Kilkenny County Council

Proposed IDA Belview Infrastructure Development at Belview, Slieverue

An Coimisiún Pleanála Case: ACP-324383-26

Submission Response

Title: **Proposed Detail Drawing Of Concrete Box Culvert**

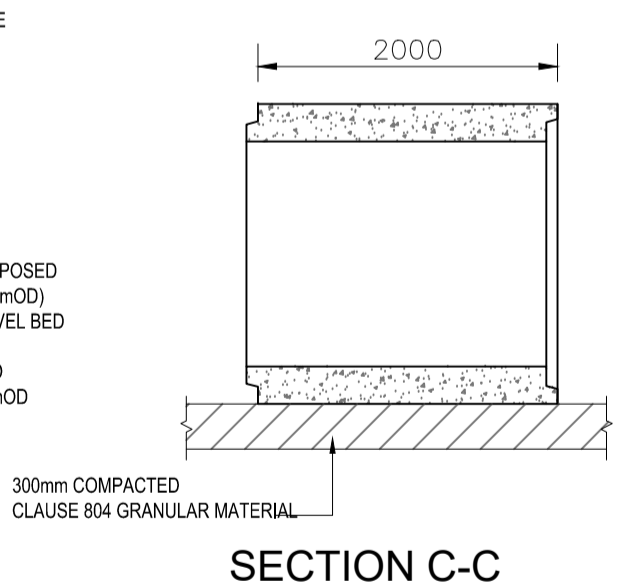
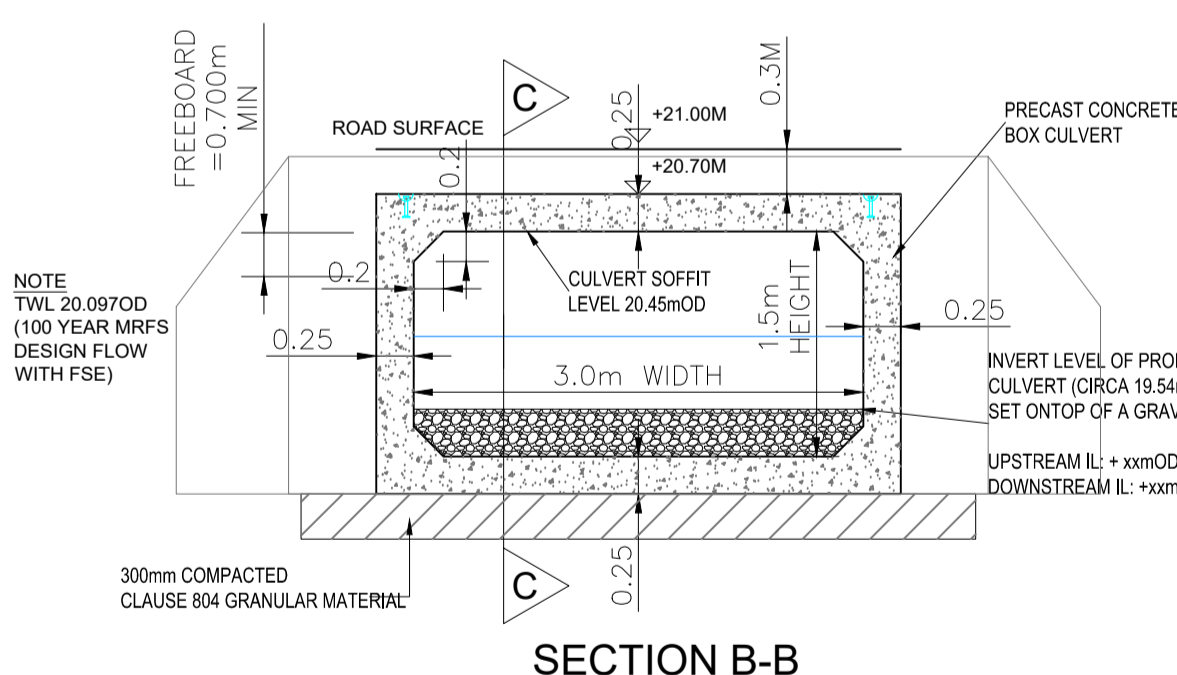
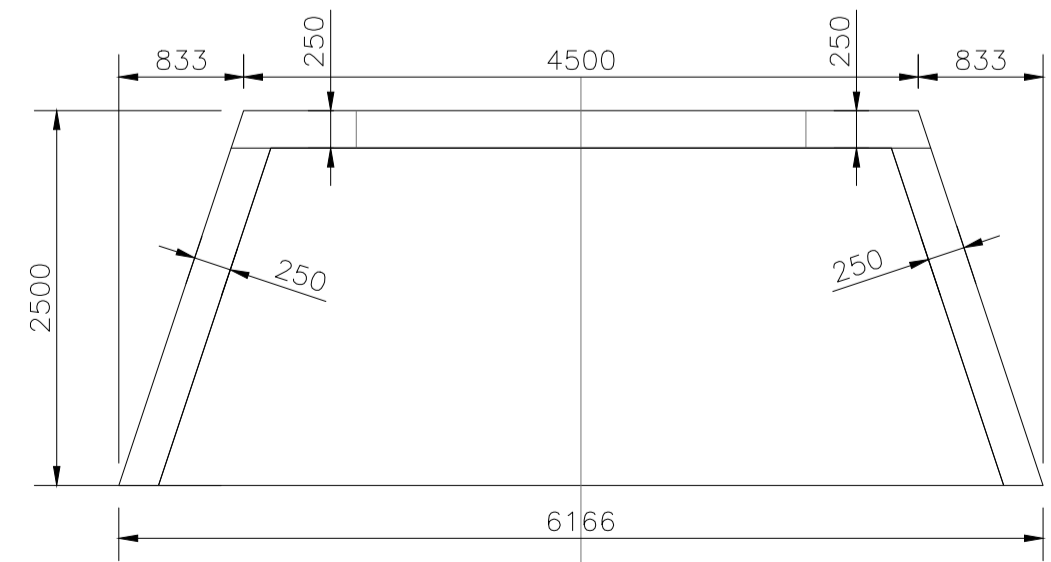
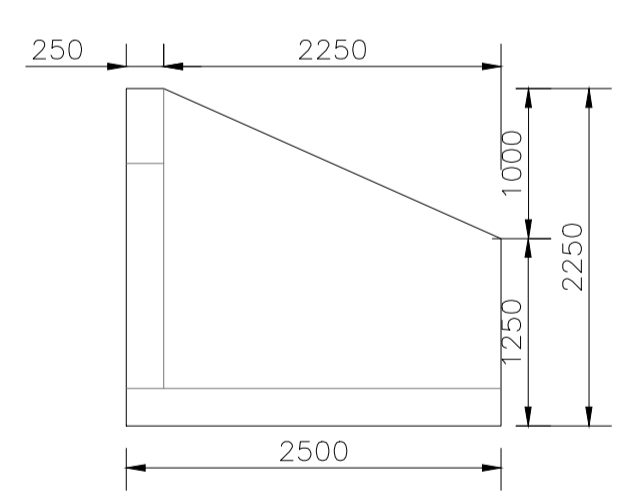
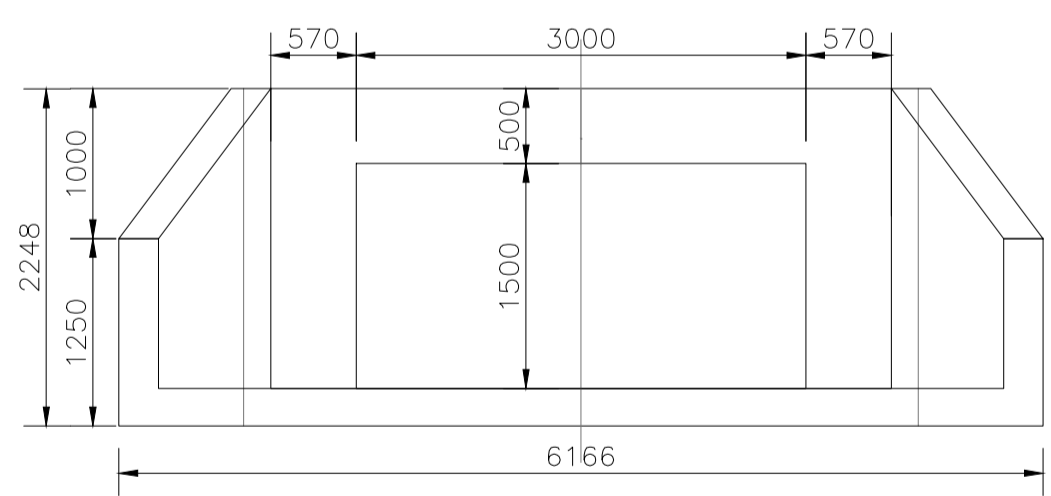
Item 3.6: Flood Risk Assessment Gaps

Response : The Engineering Planning Report (Section 4.5 – Culvert Design) and Part 10 Report (Section 5.1.1) confirm that an application to the Office of Public Works (OPW) under Section 50 of the 1945 Arterial Drainage Act has been submitted and is included in the Culvert Design Report.

The Culvert Design Report confirms that there is minimum 700mm of freeboard at the new bridge and this is stated in the Section 50 application. Drawing 12001-2001 and 12001-2003 indicate the proposed attenuation pond location. A maintenance plan for the culvert, attenuation pond and watercourse shall be prepared at detailed design stage.

The Part 10 Report (Section 5.1.1) confirms the proposed culvert has been designed to convey predicted flows safely without restricting capacity or increasing upstream or downstream flood risk (including allowing for climate change).
